13 January 2026  
Our Ref: 6980

**RE: VEHICLE ACCESS, WEST BARN NORTON LANE, ALDINGBOURNE. PO20 3AF - PLANNING APPLICATION AL/107/25/PL**

REFUSE VEHICLE ENTRY

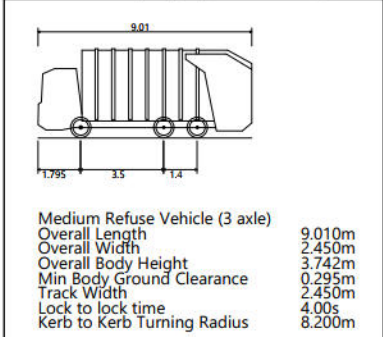
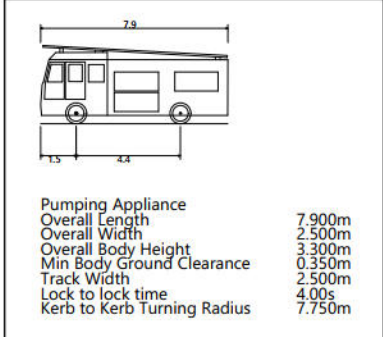
BioDot's existing operation requires HGV deliveries to and from the site. Due to the constrained geometry at the site access, HGV's are required to park on Norton Lane for Loading and unloading purposes. Whilst an allowance has been made for a 7.0m vehicle to turn in the site it is known, and evidenced, that larger HGV classes require access to the site (see below photograph).

1. The access geometry, third-party land constraints and parking in the vicinity of the access is such that it cannot not support the majority of HGV vehicle classes (anything over 9.4m length) as shown in **Drawings 2026-6980-002** and **2026-6980-003** . The reliance on Norton Lane would therefore continue and likely intensify without the application of a restriction in vehicle classes that can serve the site.
